Preliminary (PA) Punchlist
EPC - DPW - Stormwater Section

Project Name:	Scenic View PBH Pond Amendment
EDARP Filing Number(s):	CDR229, CON2257
ESQCP Number:	ESQ2247
Attendees:	DPW SW: Dylan Finley, Ben Jones, Christina Prete, Mikayla Hartford DPW Planning: David Parkerson, Amanda Rivera, Rick Spears Developer: Joe, Robert Guevara
Date of Walk-Thru:	03-07-2023
Walk-Thru Number:	1

FIGURE OS-5 TYPICAL OUTLET STRUCTURE
WITH WELL SCREEN TRASH RACK

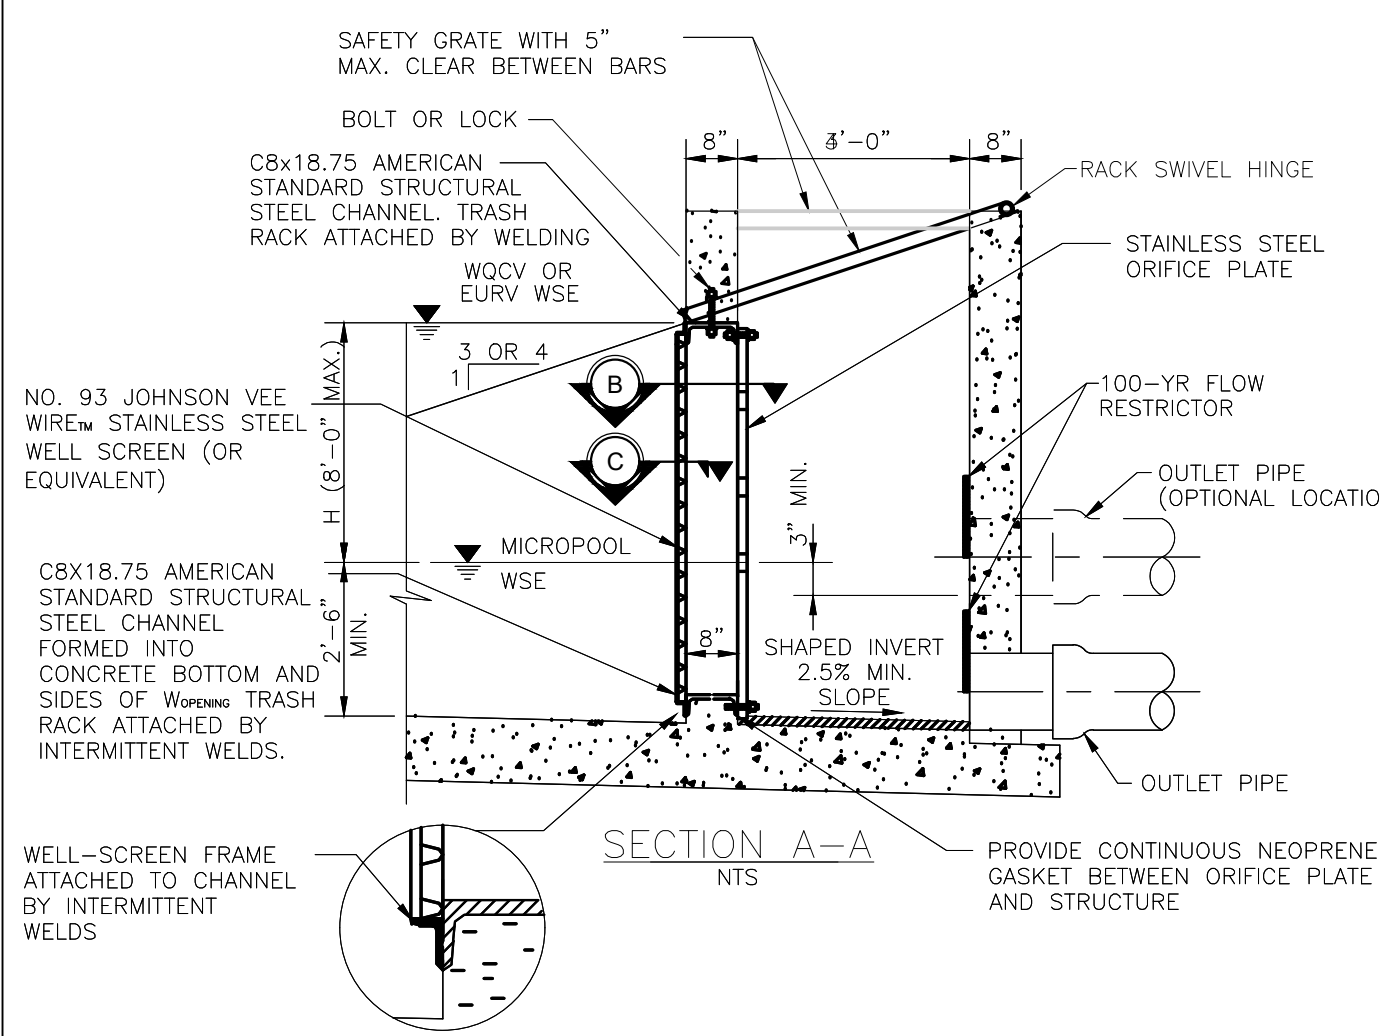
- Well screen not installed per specification. (Figure OS-5)

<p>Photo 1: Well screen not installed per spec. (Figure OS-5) Page 5 of CD's</p>
